From: Craig Milligan <Craig.Milligan@arun.gov.uk>
Sent: 17 February 2021 14:25
To: Maria Tomalova <Maria.Tomalova@arun.gov.uk>; Planning.Responses <Planning.Responses@arun.gov.uk>
Subject: Co-op Supermarket 2 Nyetimber Lane Aldwick PO21 3HG - AW/359/20/PL

Planning Application Reference: AW/359/20/PL

Proposal: Introduction of one way system & marked parking bays to the existing parking area, new armco barrier to protect shopfront, new mechanical plant at rear of store with key-klamp protection & alterations to existing timber store which include new secure metal door & new felt roof to replace existing polycarbonate roof covering. This site is in CIL Zone 4 (Zero Rated) as other development.

Address: Co-op Supermarket 2 Nyetimber Lane Aldwick PO21 3HG

Appendix D Plant layout plan

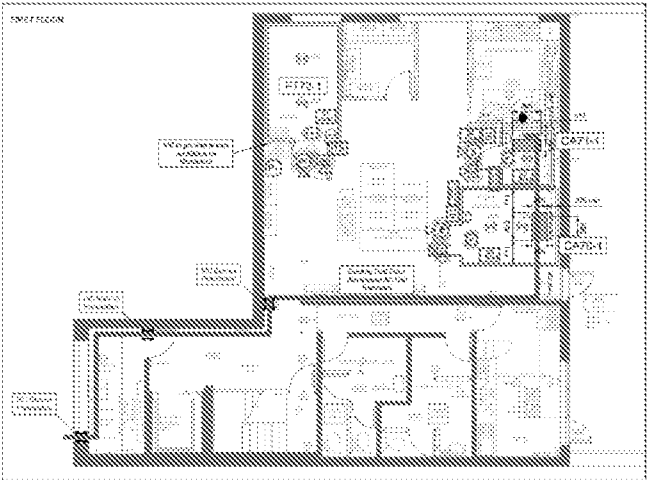
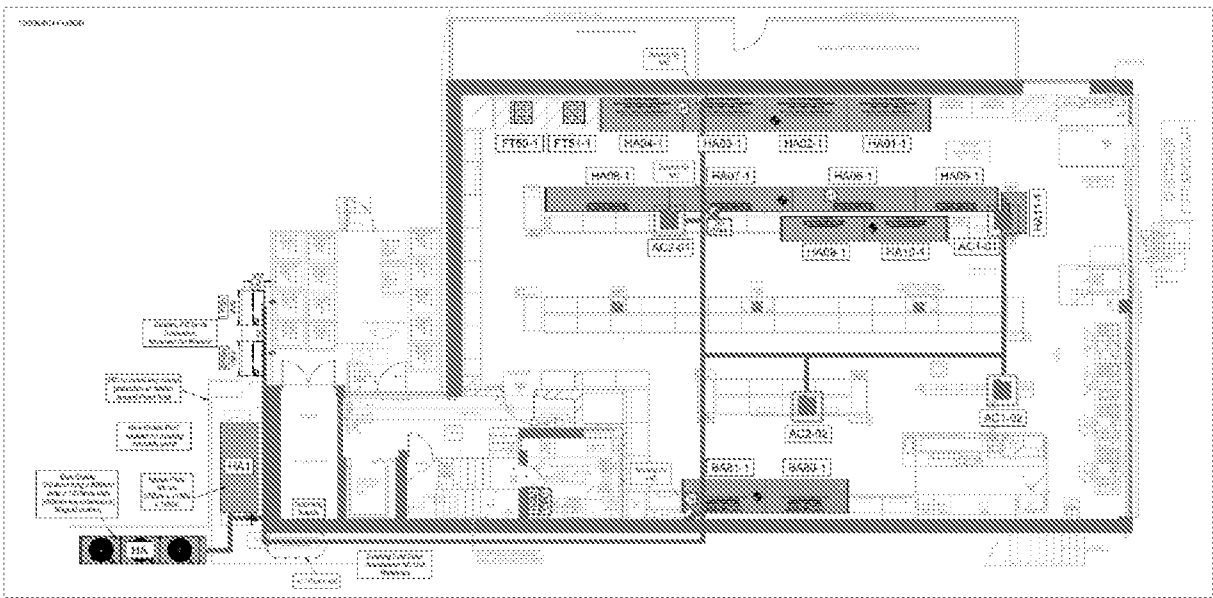
Having reviewed the Noise Impact Assessment, I find the methodology and conclusions to be reliable. I note that proposed screening has been identified to provide a sound reduction of -8dBA, however Appendix B suggests that the plant will be screened by the perimeter fence of the premises, which looks to be around 1.8 meters high. The receptor is 5 meters high and therefore the fence is not likely to provide significant noise attenuation.

Despite this factor, the impact assessment demonstrates that plant with a sound pressure level of 20dBA at 10 meters will not exceed the background noise levels measured in the assessment.

Noise emitted from plant and equipment 'Kelvion GF-SA103F5H-063 HA Gas Cooler' and 'Space ST3A HA1 Pack' located at the site shall be controlled such that the Sound Pressure Level is in accordance with Appendix E of the NSL Noise Impact Assessment – does not exceed 20dBA at a distance of 10 meters.
